BE/13/20/PL

Rear of Blackberry House Berry Lane North Bersted PO22 9AF

Single storey dwelling with detached carport (alternative to BE/64/17/PL).

TITLE
FLOOR PLAN

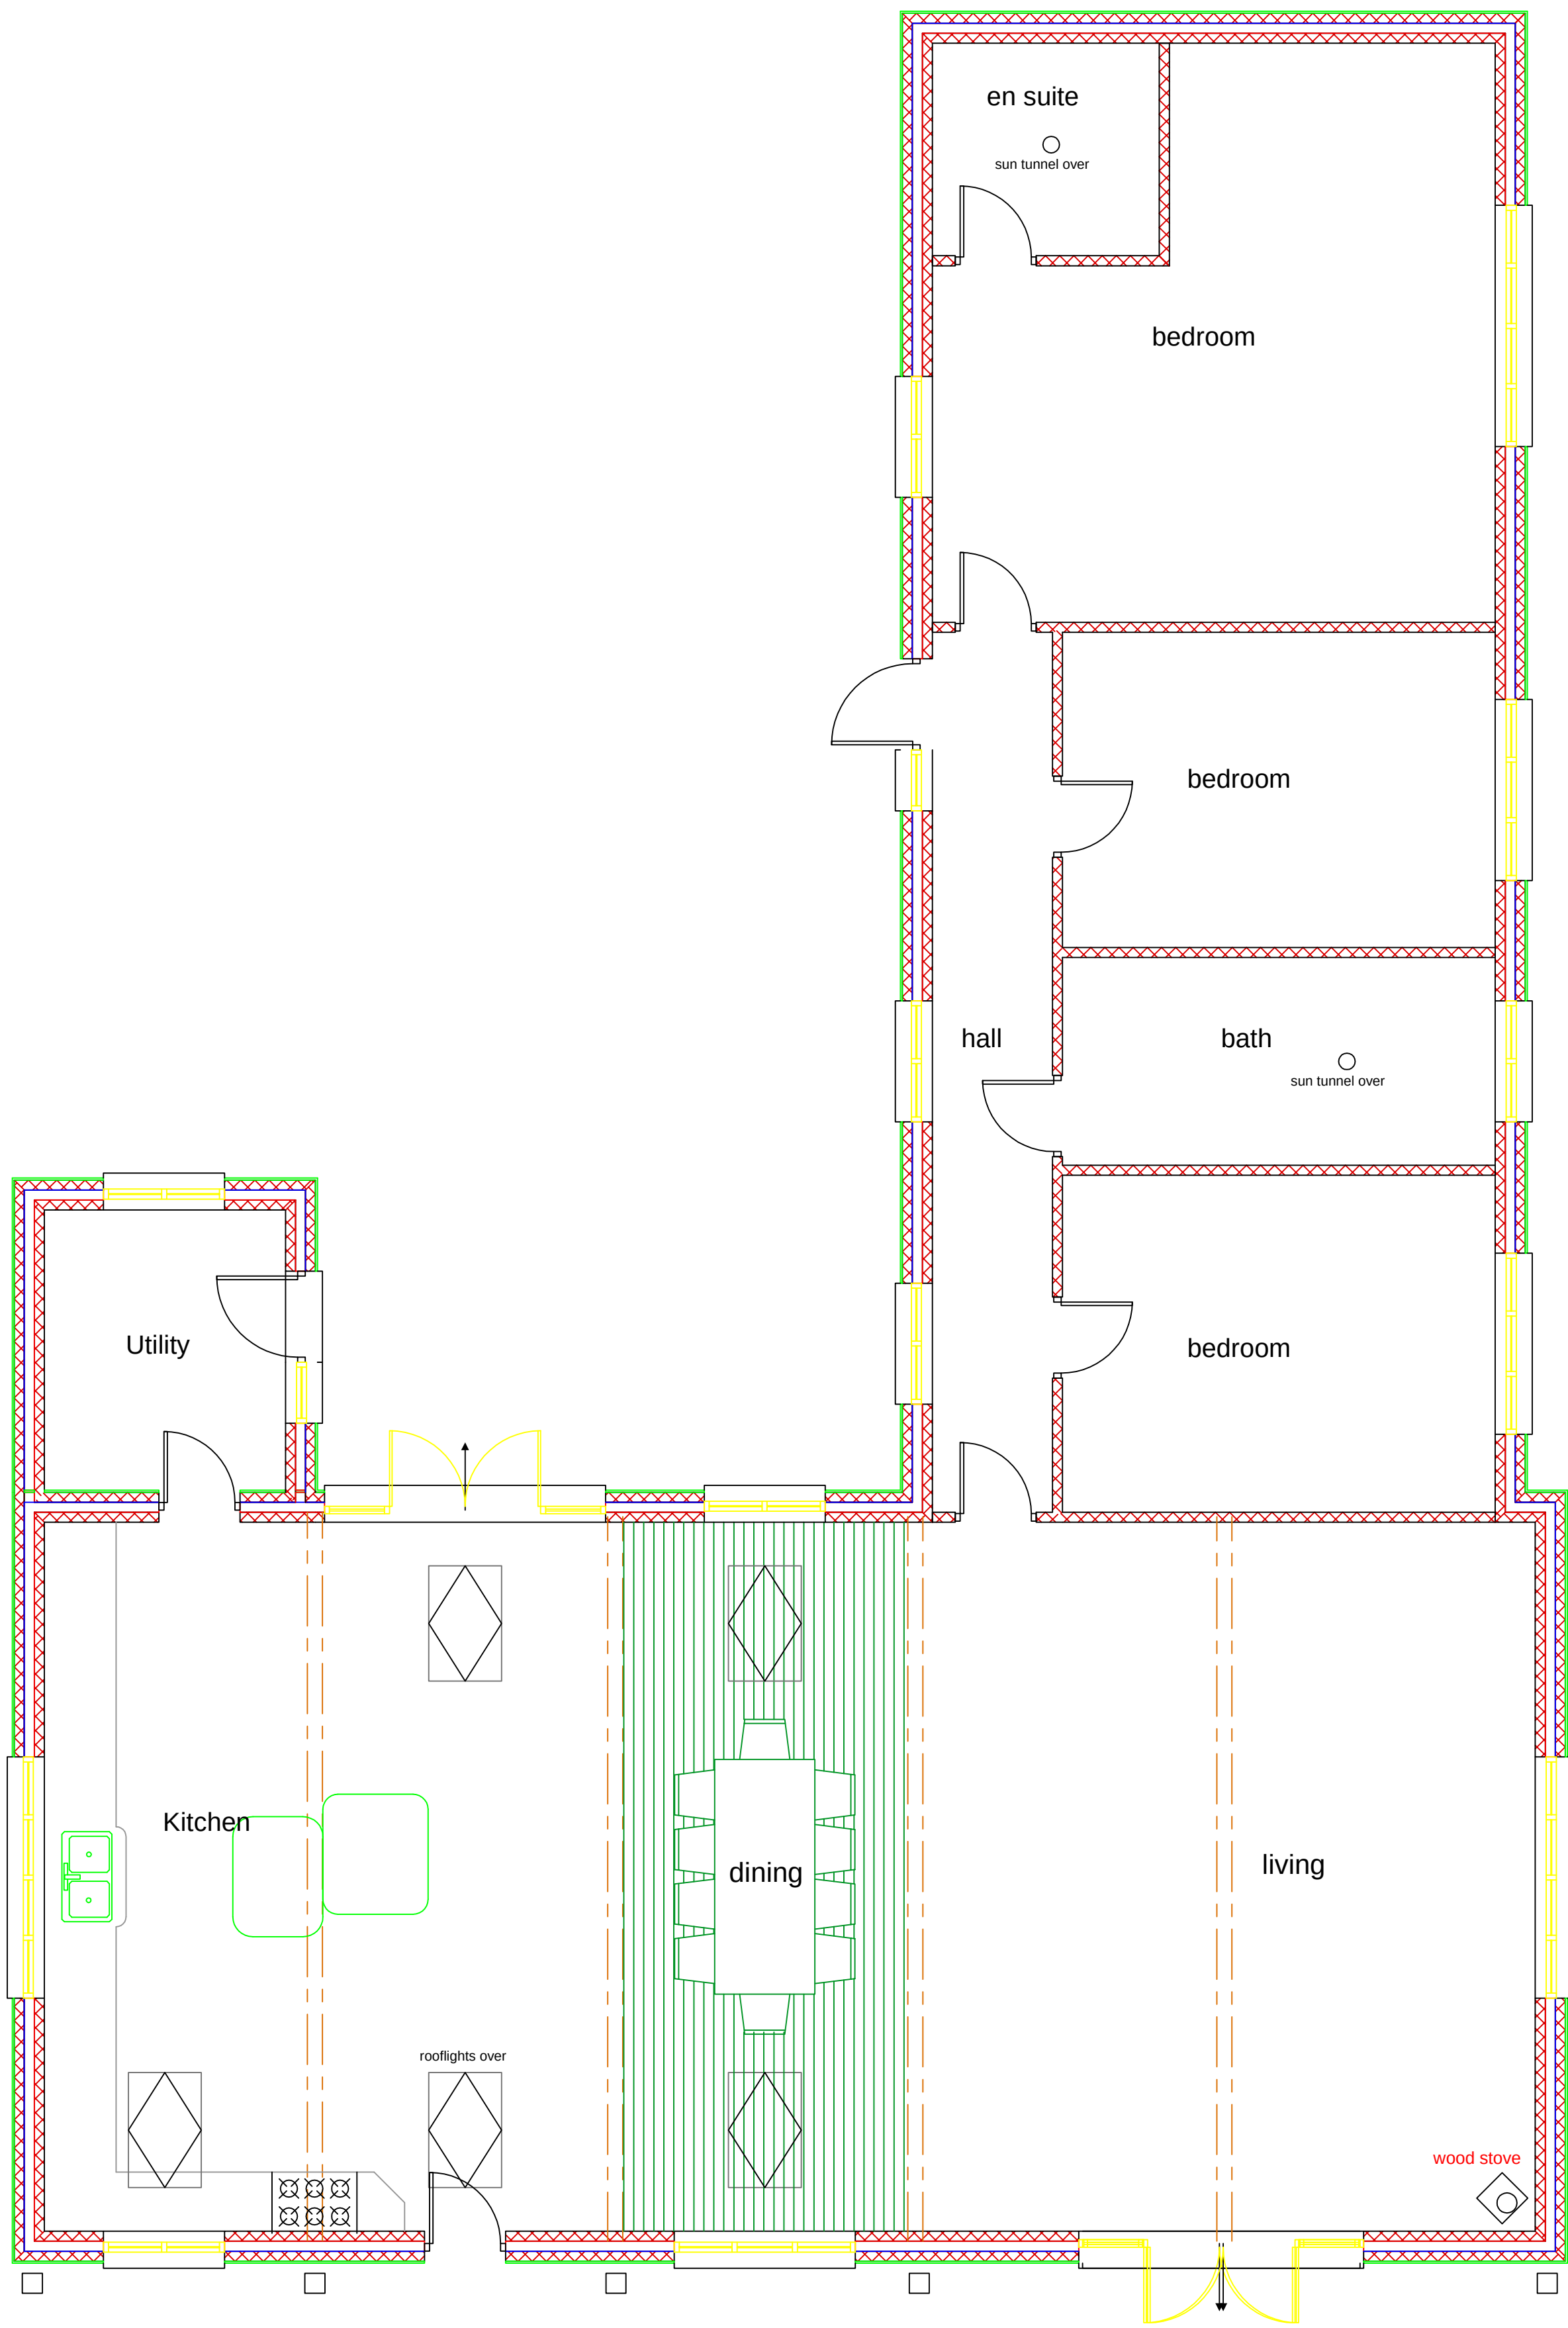
It is unfortunate that such a large area appears to be proposed for hardstanding; it covers the entire width of the plot and would potentially urbanise the curtilage. Could the hardstanding either be reduced in size or designed so as to not look so suburban in character? If minded to approve the application, could this issue be dealt with by way of a landscaping condition?

CLIENT		PROJECT		TITLE	
M. GRANGER		BERRY LANE NORTH BERS TED		ELEVATIONS	
DRAWN BY		CHECKED BY		DATE	
SJ		SJ		05.02.2020	
SCALE		DRAWING NUMBER		DATE	
1:100@A3		SE		05.02.2020

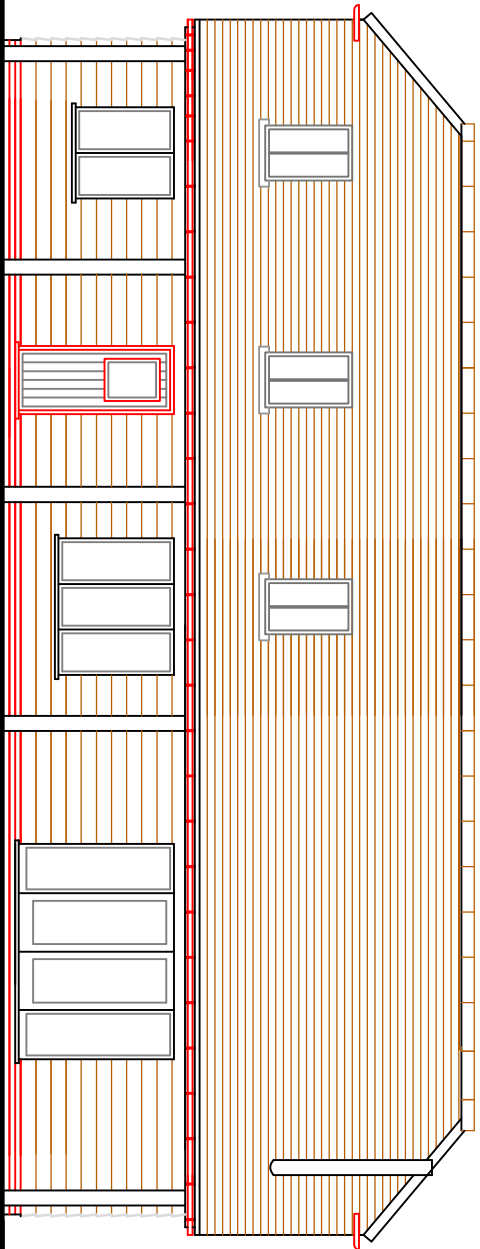
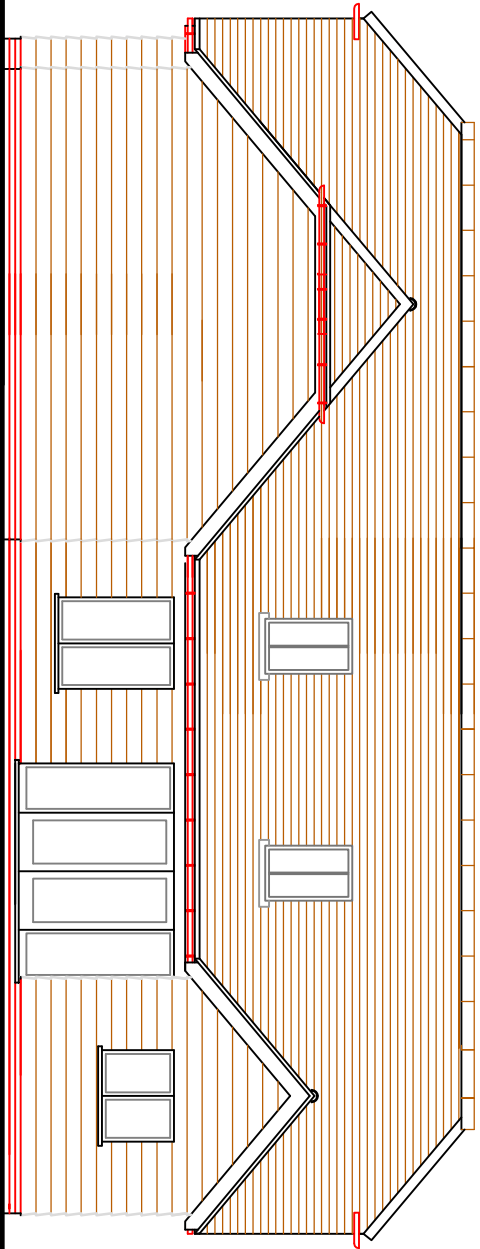
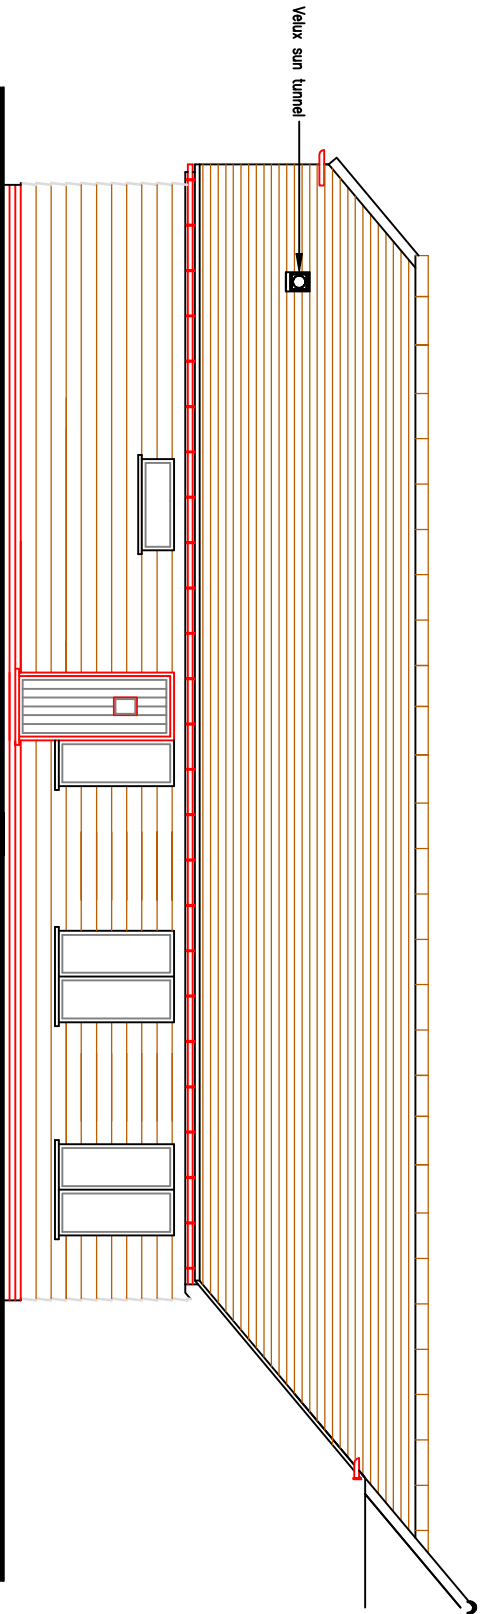
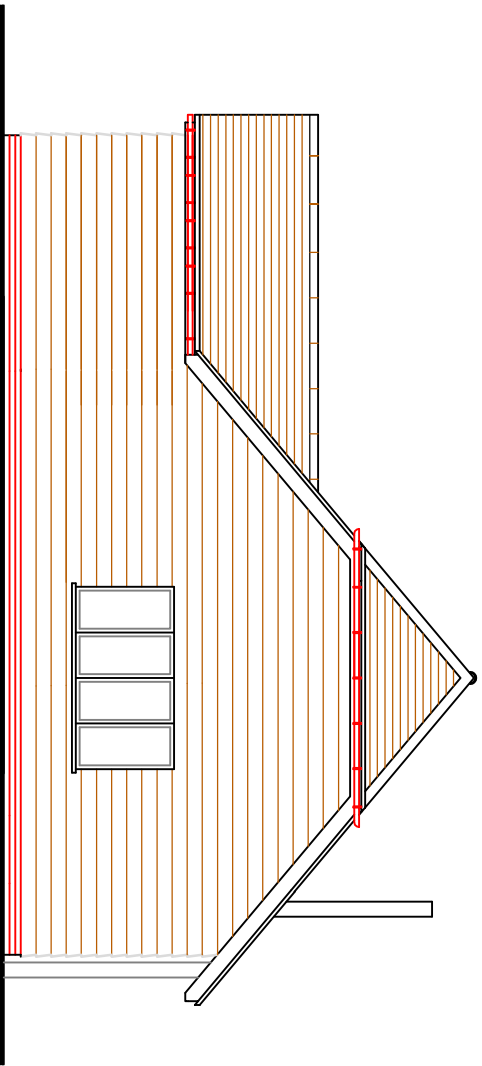
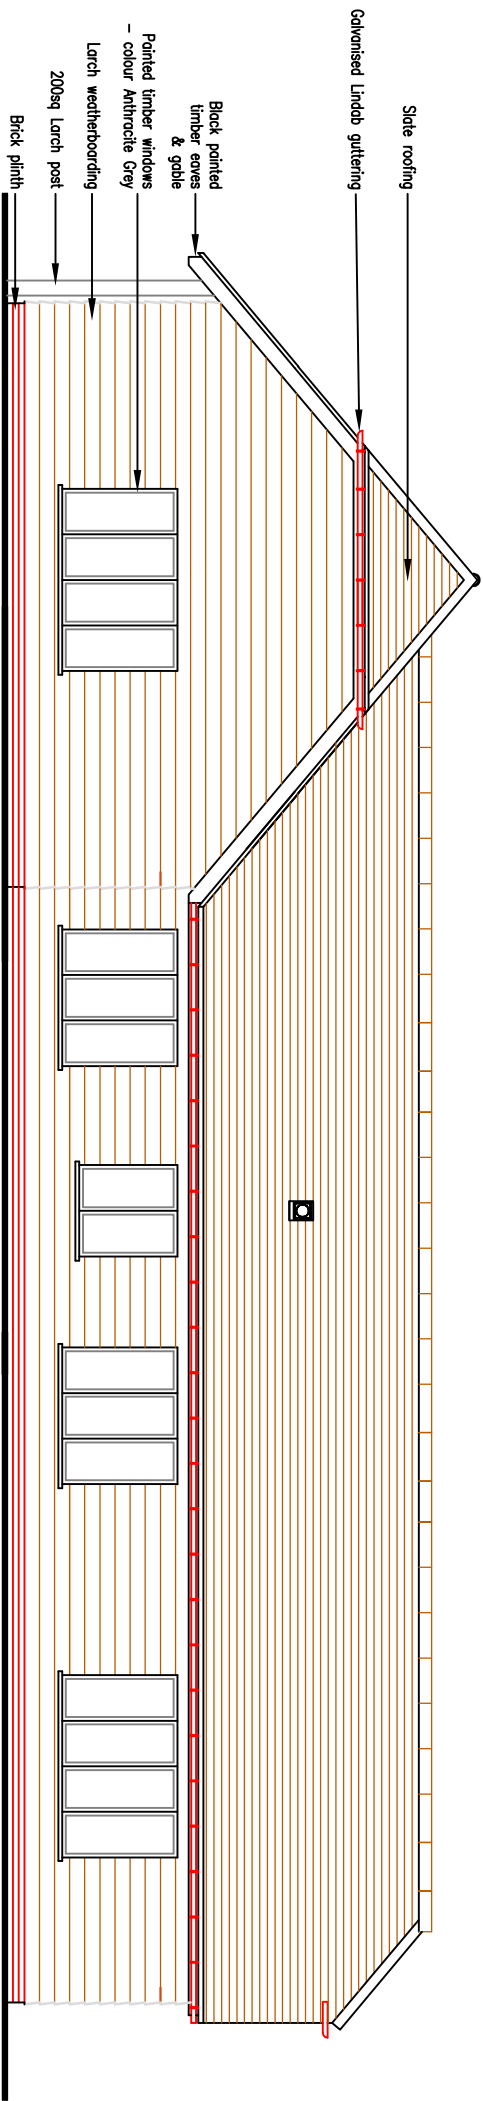
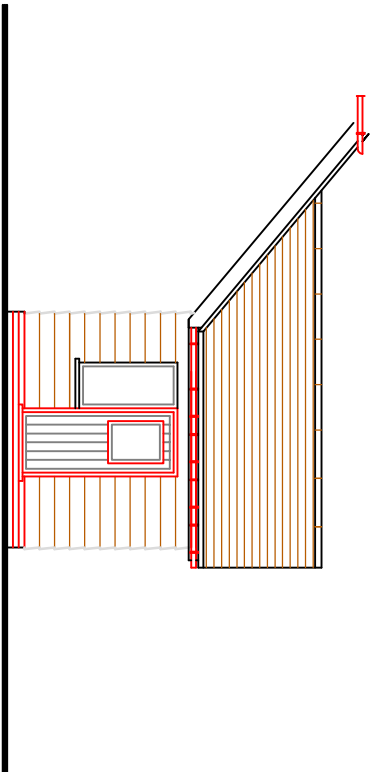
The success of such a scheme will depend upon the quality of the materials/finishes used, as well as the style/appearance of the joinery. It is noted that the applicant will be using materials such as brick, a timber frame, oak cladding and plain clay tiles. Such an approach is positive, but you may wish to condition details of these materials, along with the joinery in order to ensure that they reflect the character of the locality.
